25 May 2018

Re: Submission – Application Number SSD 8658
Gunnedah Solar Farm Pty Ltd - 765 Orange Grove Road, Gunnedah
(Lot 1 DP 1202625, Lots 151, 153 & 264 DP 754954, Lot 2 DP801762 and Lot 1 DP 186590)

Council would like to make a submission in regard to the proposed development.

Figure 1: Site plan

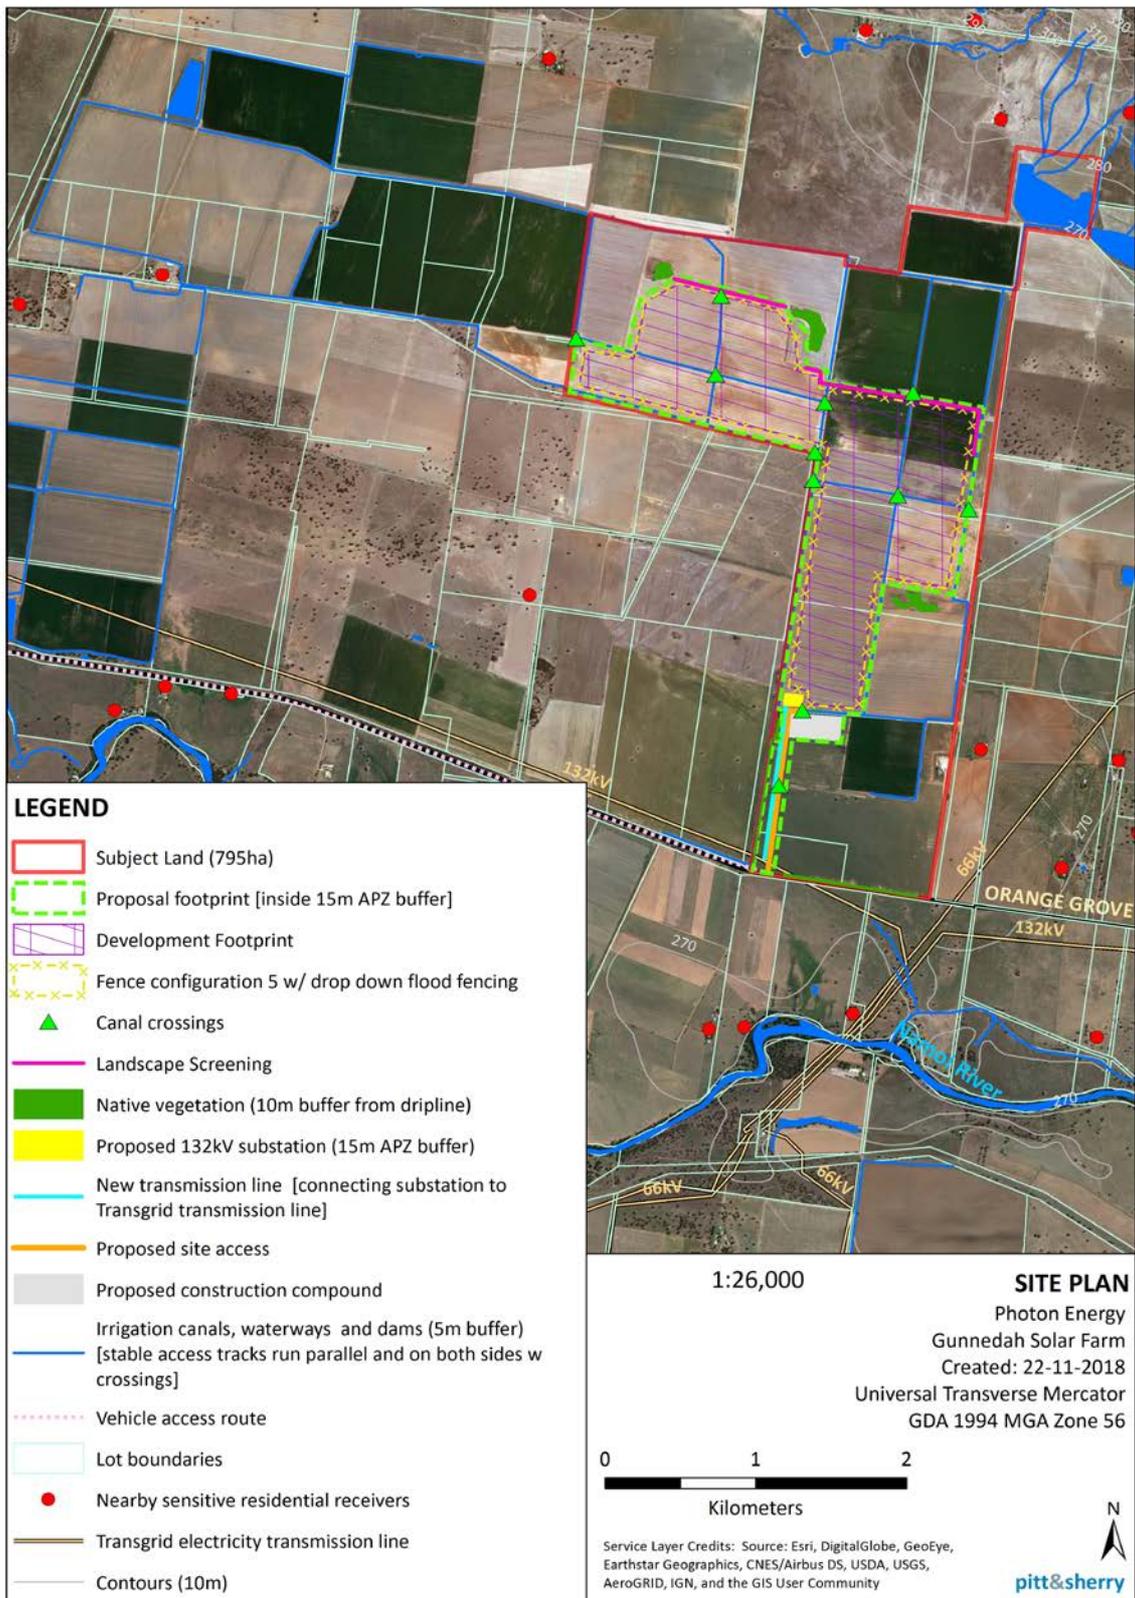
It is advised that the site plans and maps provided with the Environmental Impact Statement (EIS) are difficult to review. For example, clarification is requested in regard to the proposed use of the unsealed, unnamed road off Orange Grove Road, located near the western boundary of the site. Council's mapping does not illustrate any "road" to the west of the site, only an internal farm road, that could possibly be located within the adjoining property (which is not included in the development application). A more detailed site plan should be prepared to determine if the "road" is located on the development site.

Figure 11: 1984 Flood Hydrograph at site and scaled hydrographs for different AEPs

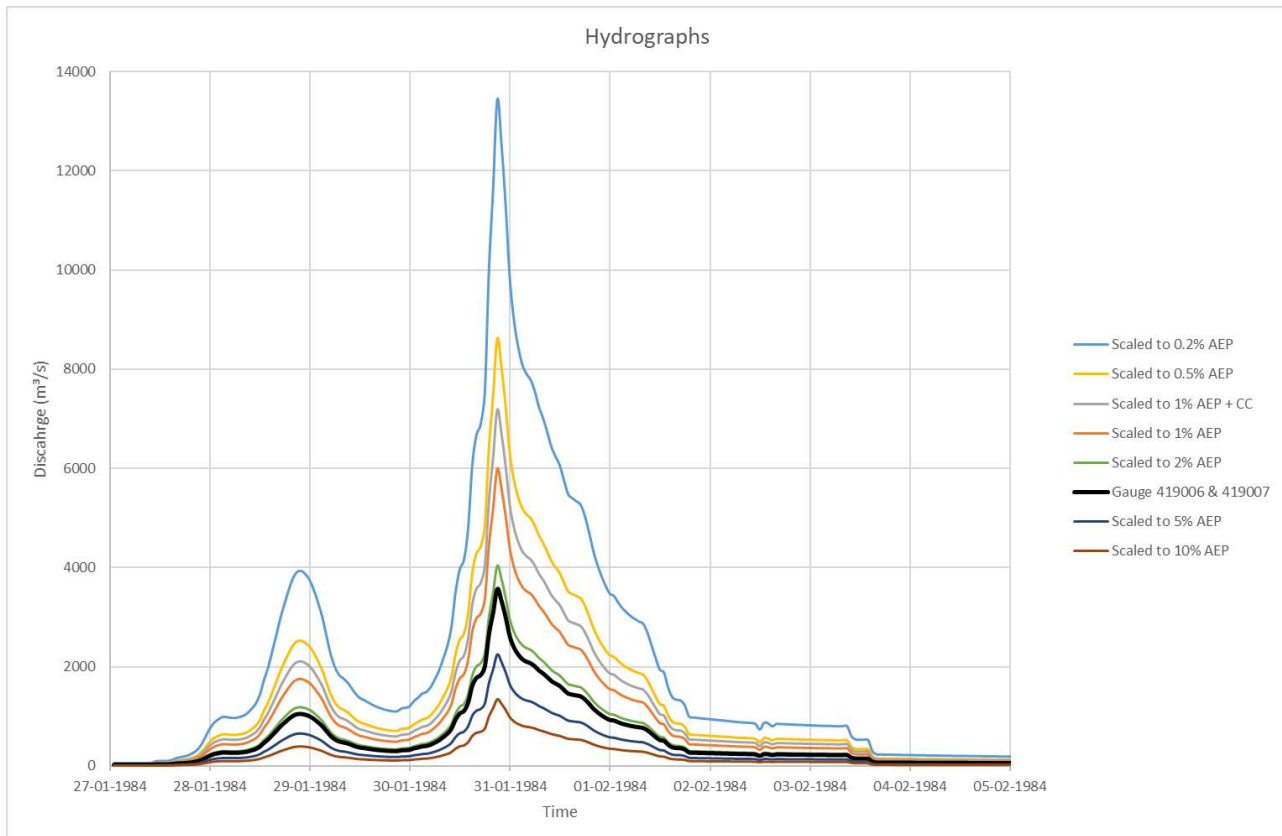
The Flood Impact Assessment notes that the 1984 flood event was the largest event recorded for the gauges at Carroll Gap and downstream Keepit Dam (being more than 25km from the site). The records from these gauges were utilised in the hydraulic modelling and scaled up to yield hydrographs for a range of AEP events. Clarification is requested as to why the 1955 flood event data (being the event closest to the 1% AEP flood event) or records from the gauge at Gunnedah was not utilised in the hydraulic modelling. Other tributaries feeding into the area, which also impact on flooding particularly at this site, should also be considered to ensure accurate flood modelling.

Figure 19 Location of electrical substation and flood depths for 1%AEP Configuration 3

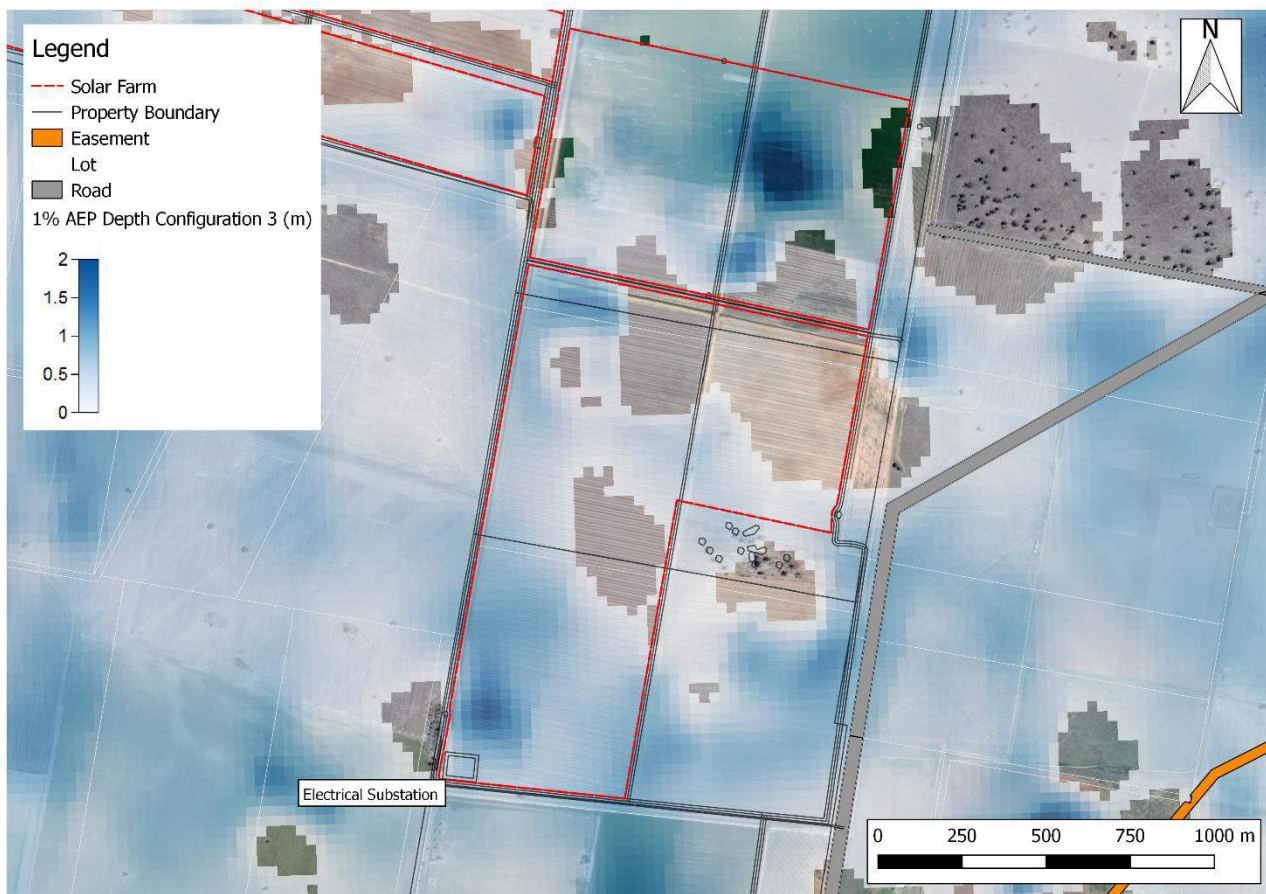
The EIS has limited details regarding the proposed earth mound for the substation and whether it will result in any impact on the adjoining property, as it was not included in flooding configurations modelling. It is recommended that the flood configuration modelling be updated to include the substation earth mound.

## APPENDIX 4: SITE PERIMETER SECURITY FENCING

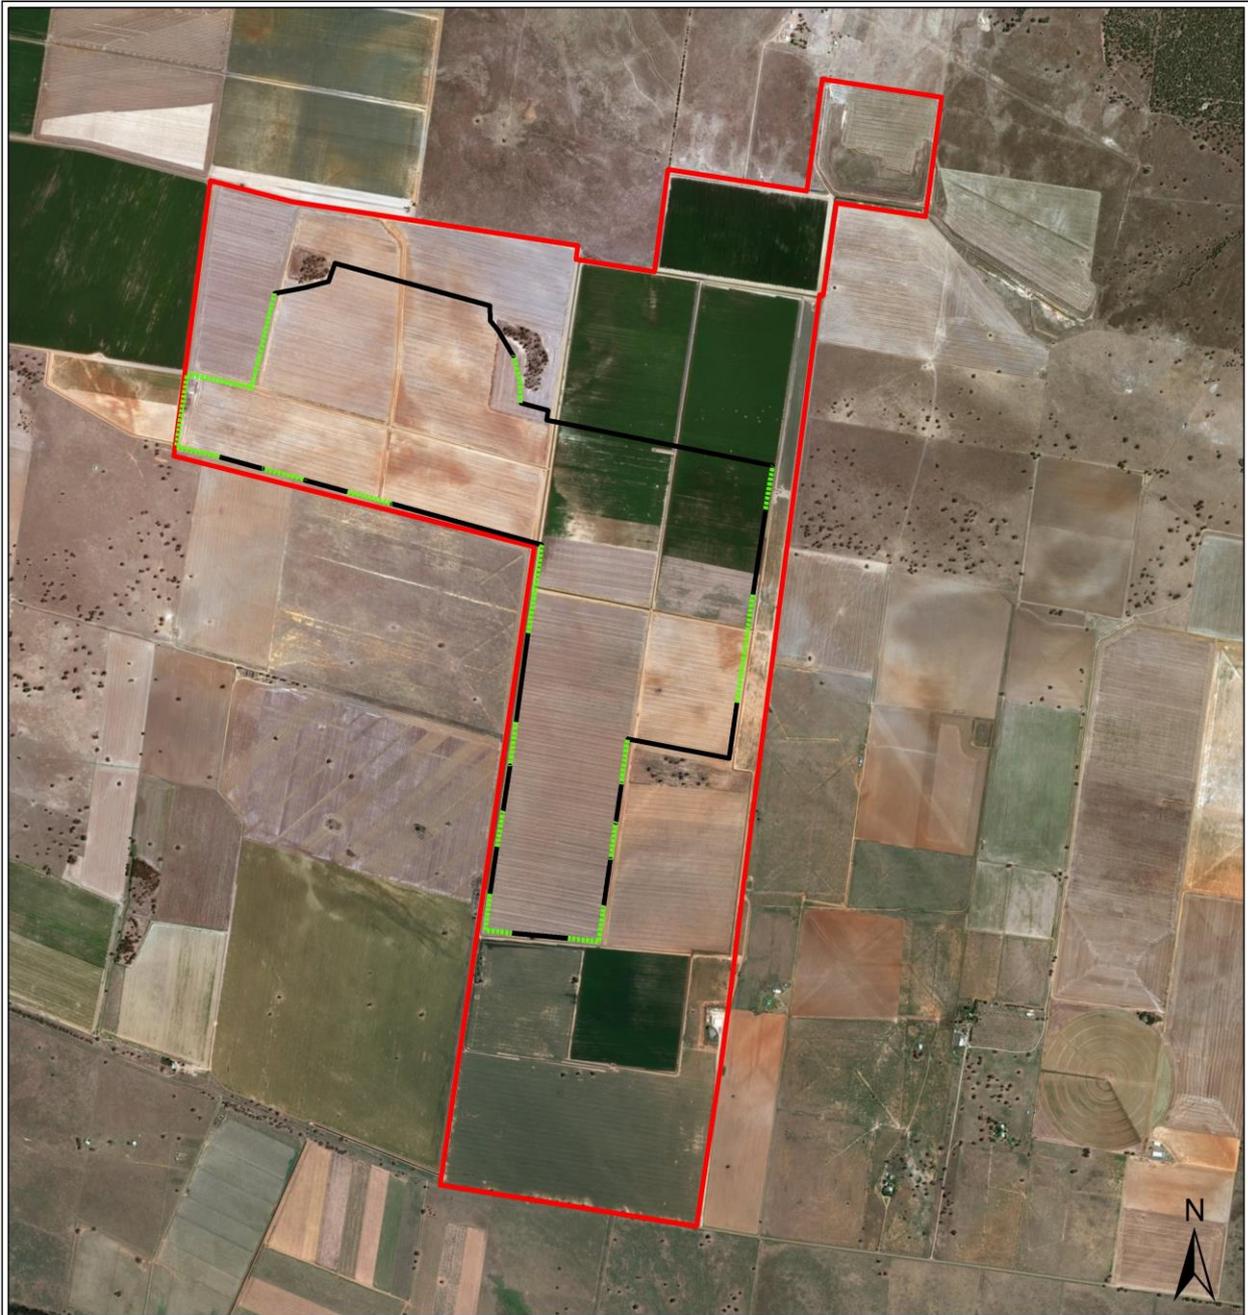
The EIS mapping of the proposed security fencing, illustrating the locations of the proposed laneways, is not of an adequate scale to review. It is noted that the site is to include remote monitoring. Hence, further detail is requested in regard to how the proposed flood measures will be implemented during a flood event.
